# ENG-PUDSP22005-R2-GEC redlines.pdf Markup Summary

**Subject:** PolyLine  
**Page Index:** 2  
**Date:** 10/17/2022 11:24:03 AM  
**Author:** dotprete  
**Color:** ■  
**Layer:**  
**Space:**  
**Page Label:** 2 INITIAL GECP

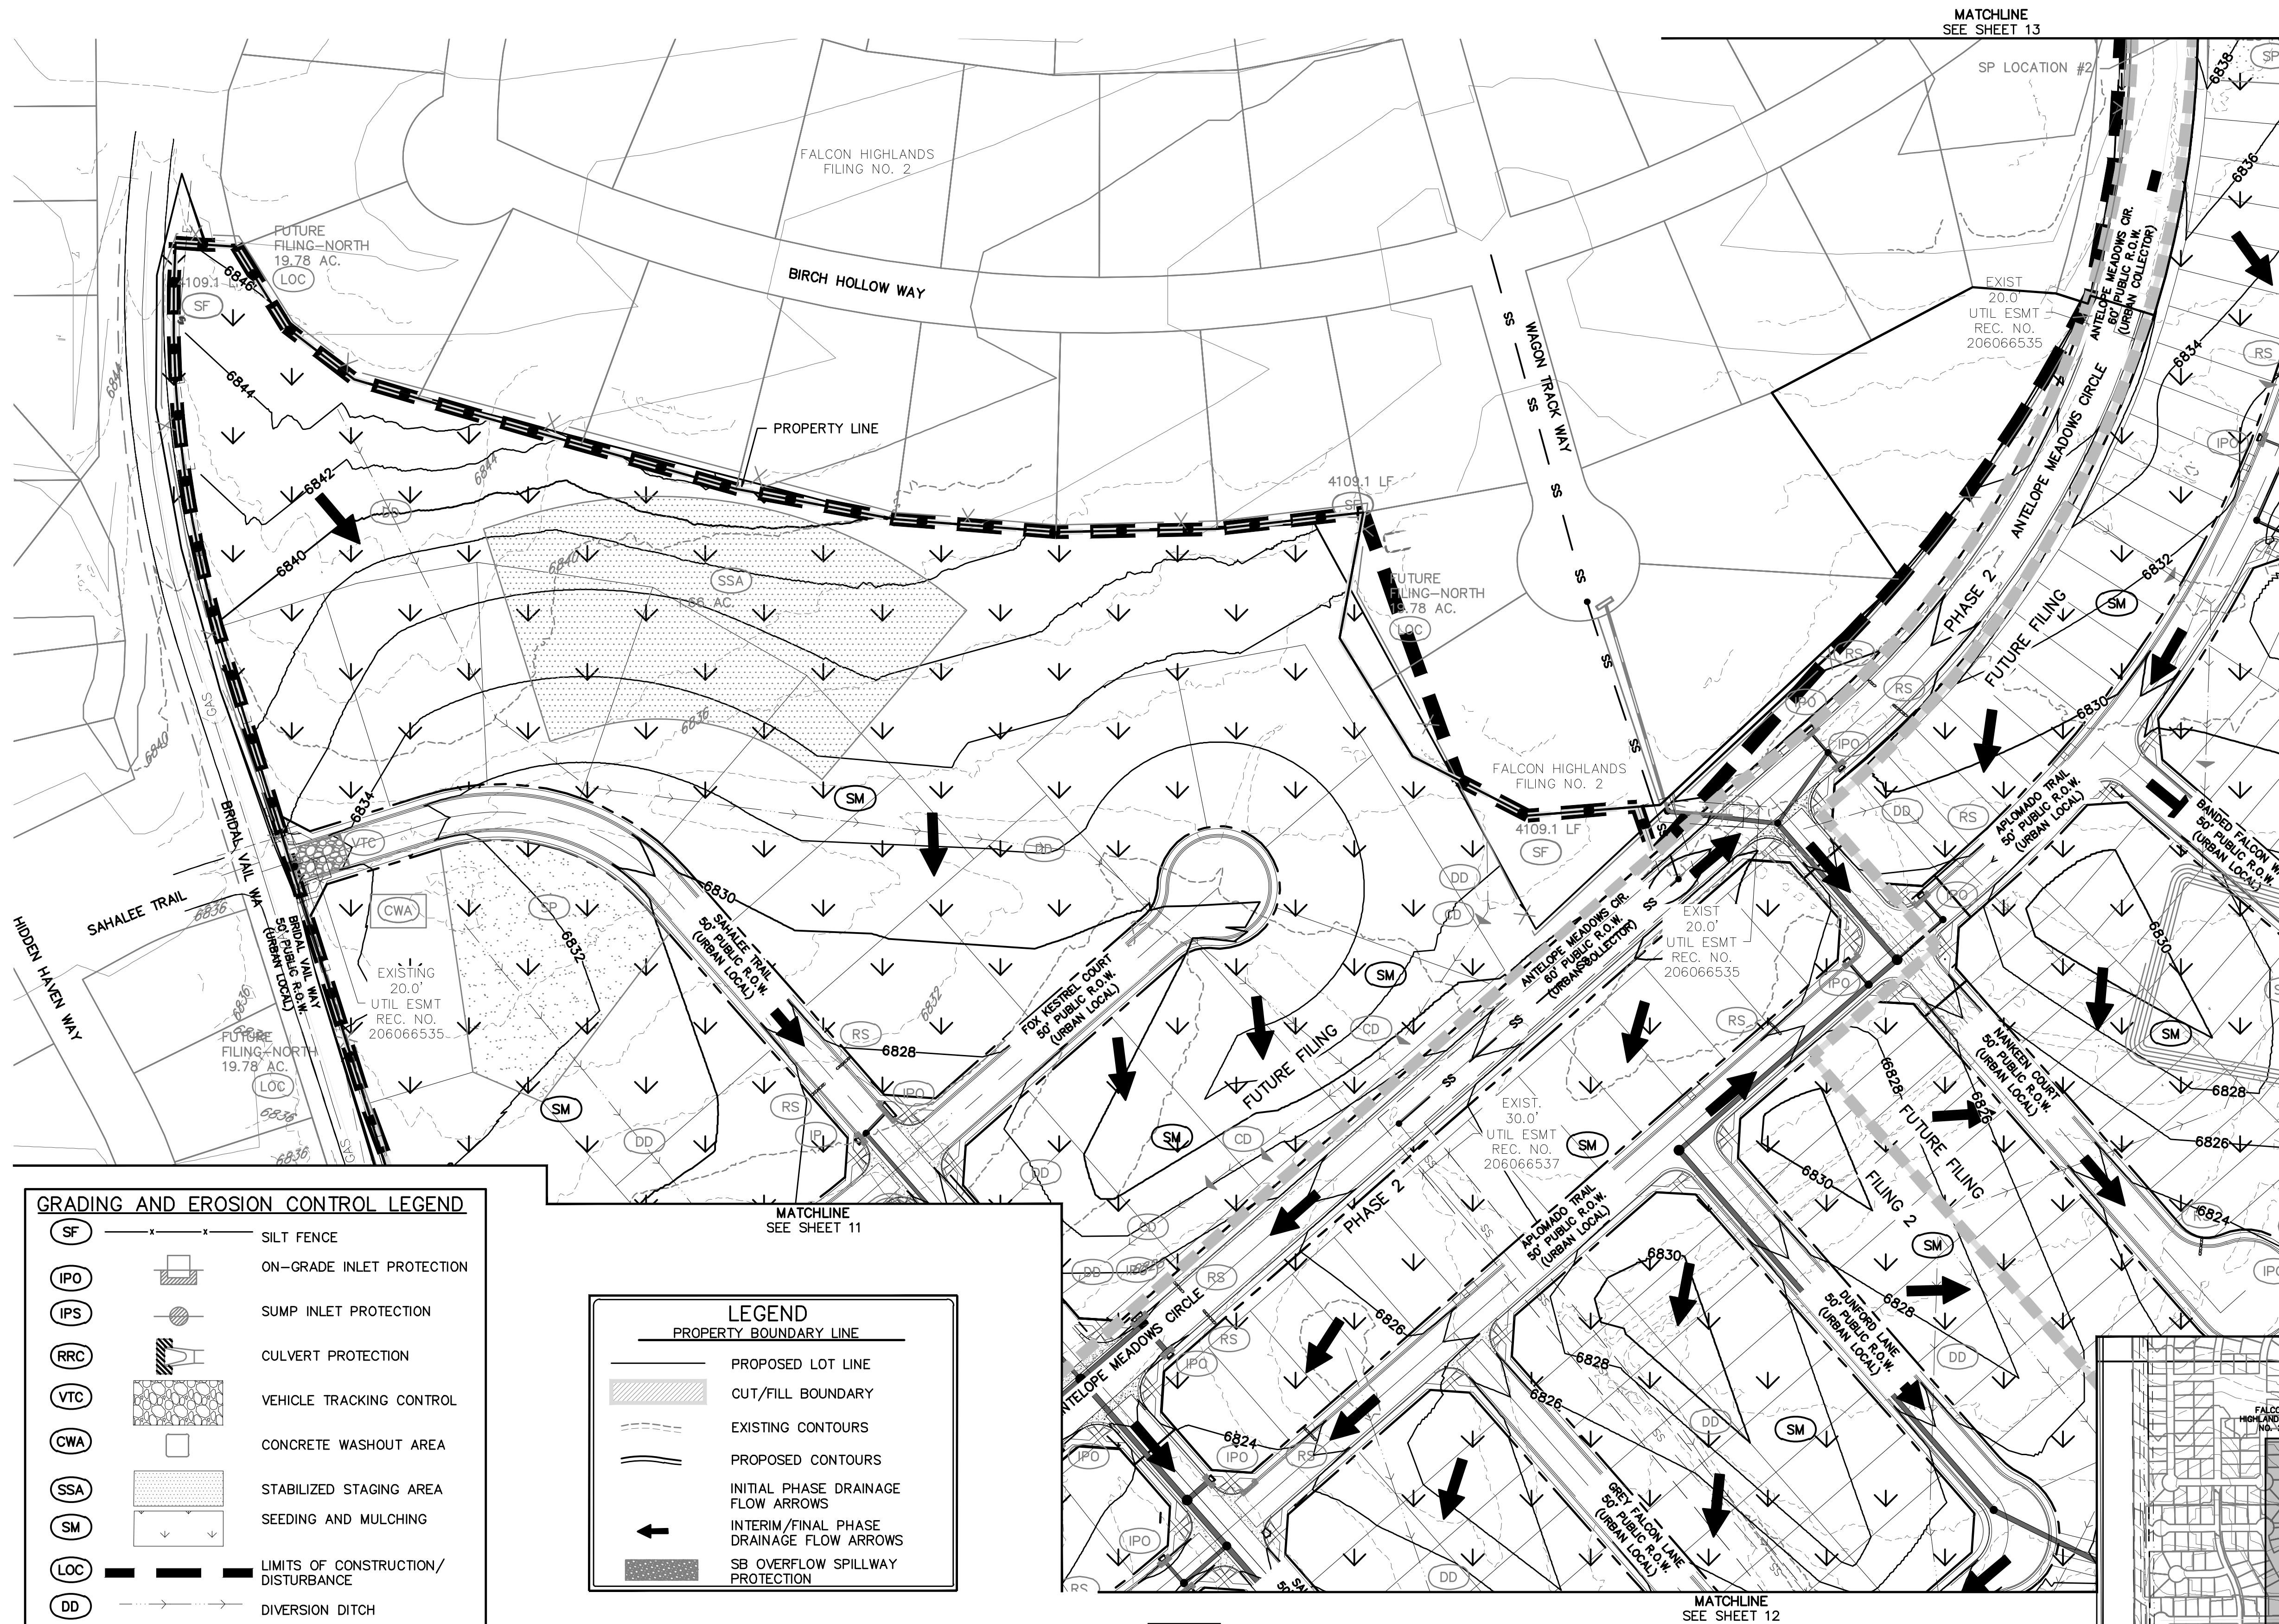
do not label this proposed if its not part of this project (future?)

adjust existing flows to match existing contours

remove VTC

Add symbol to legend

JOB: 21005234 SHEET NO. 11

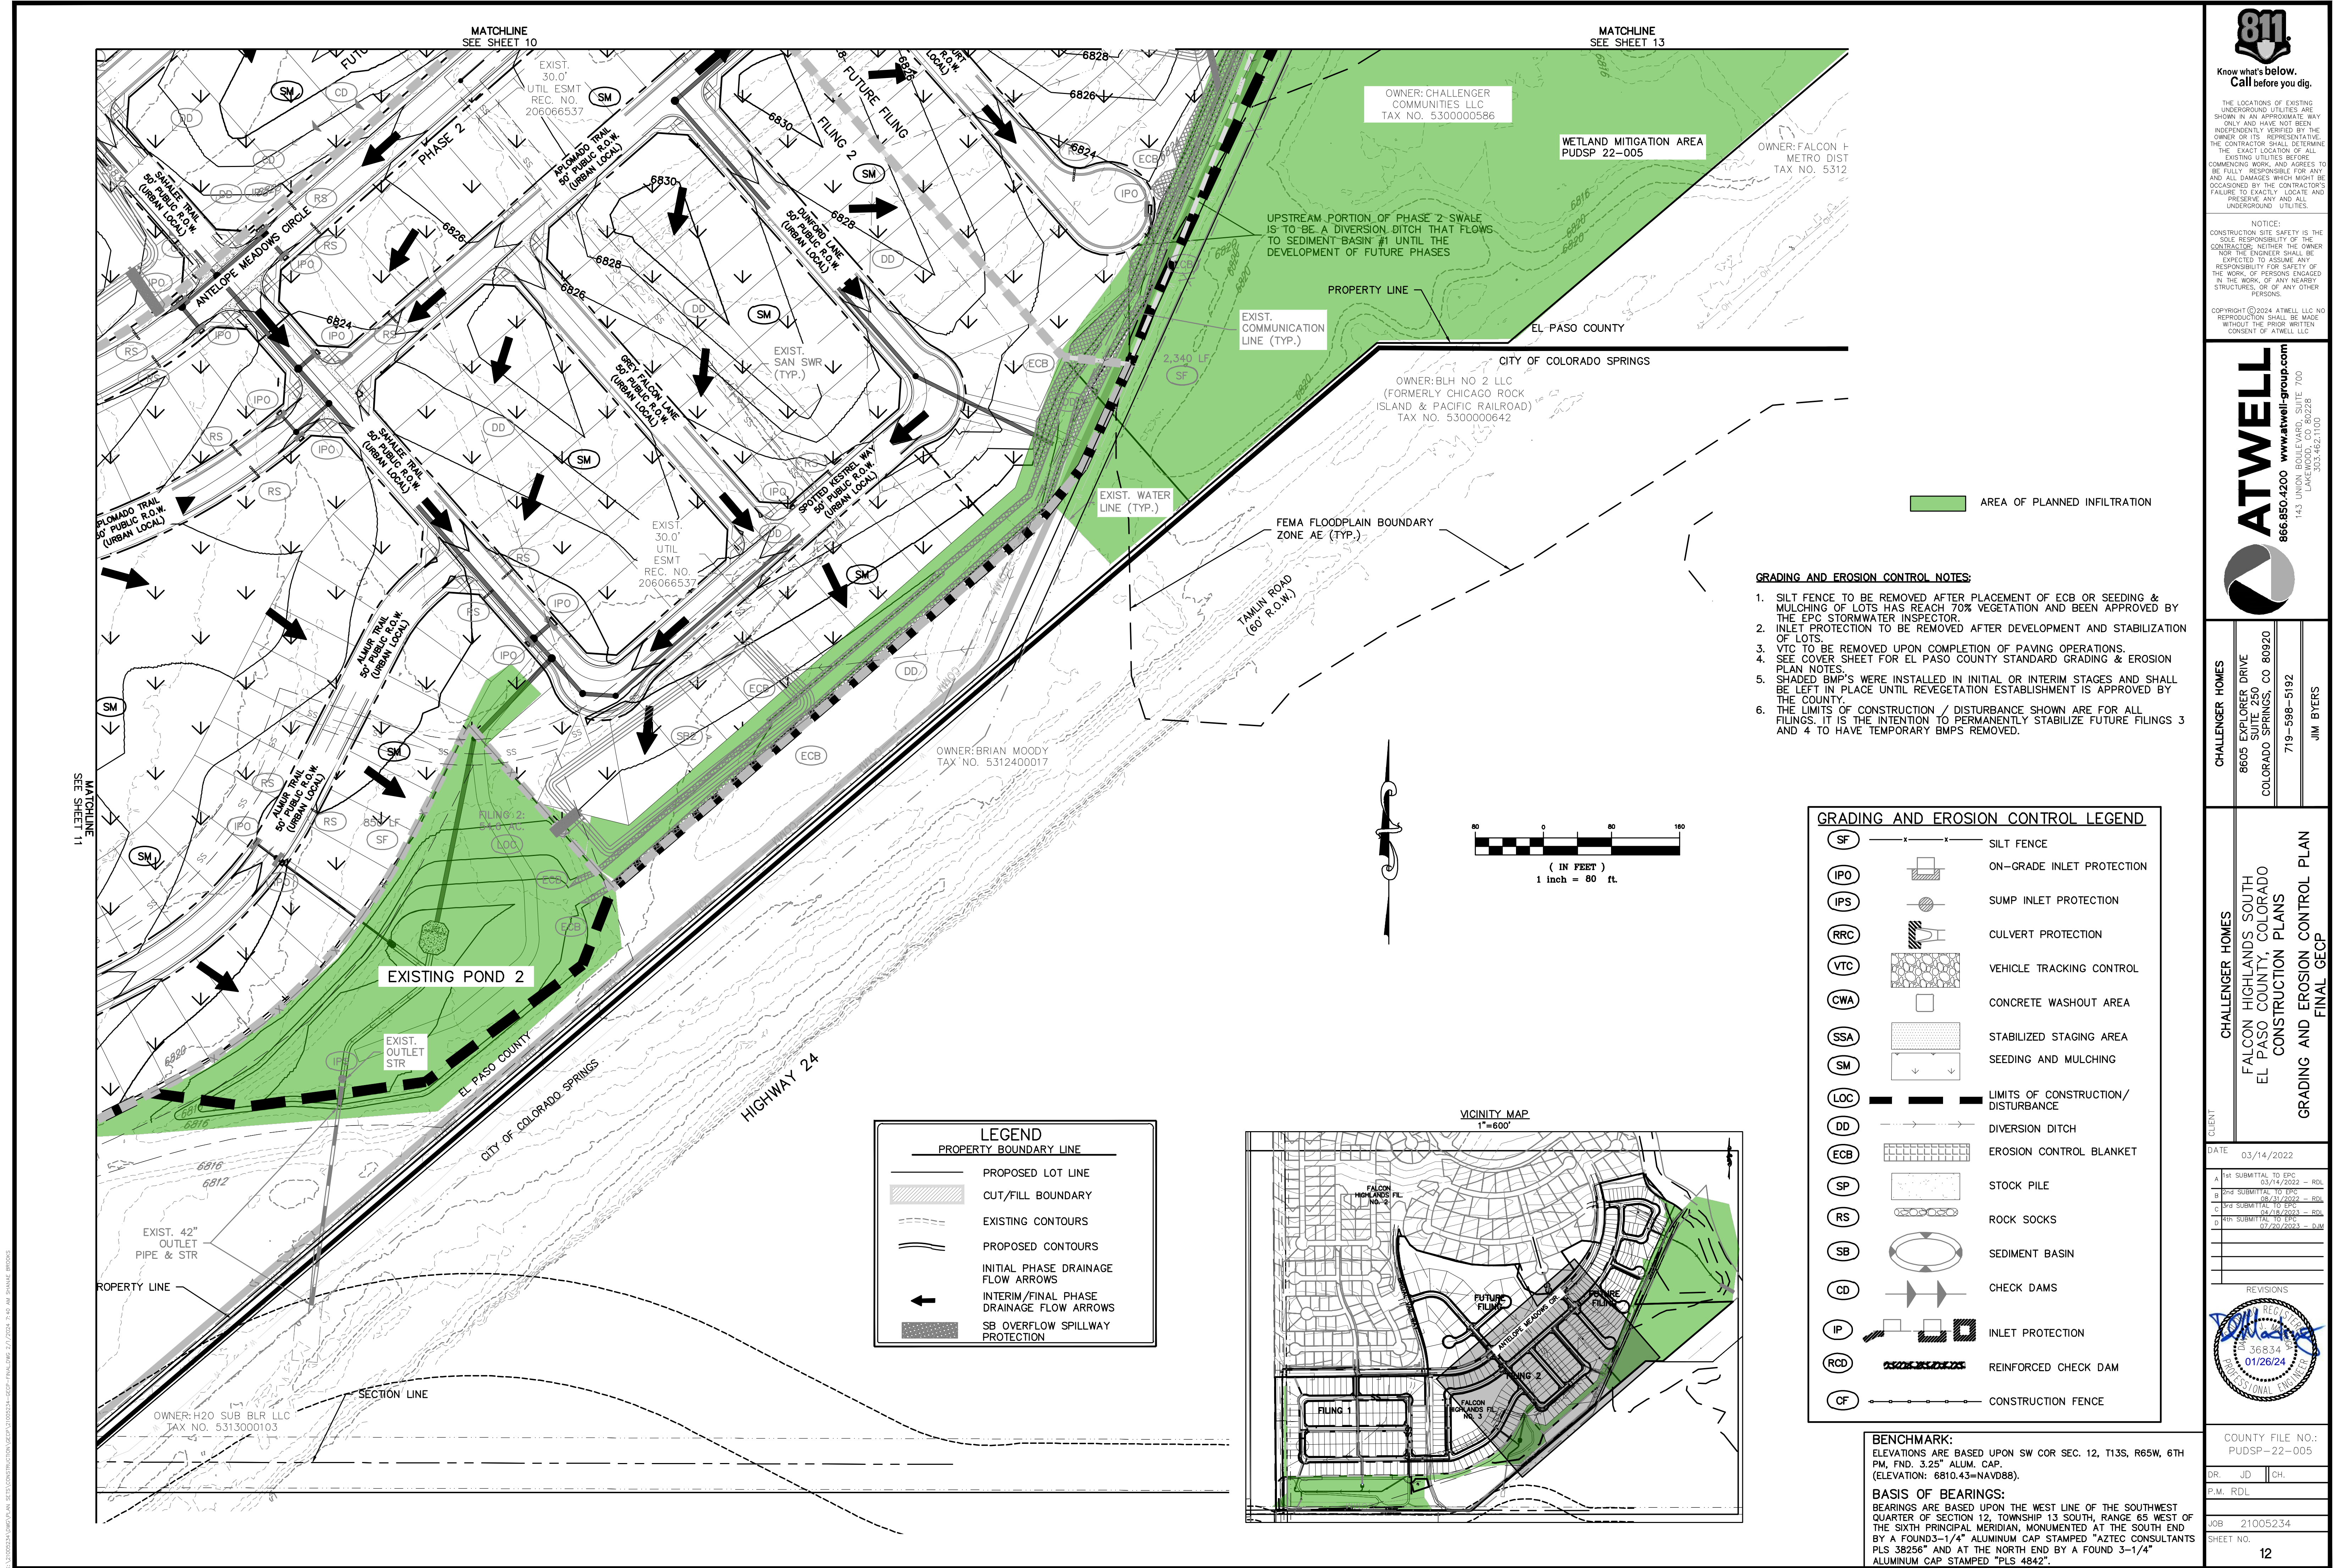
show seeding and mulching

label contours

Show existing contours
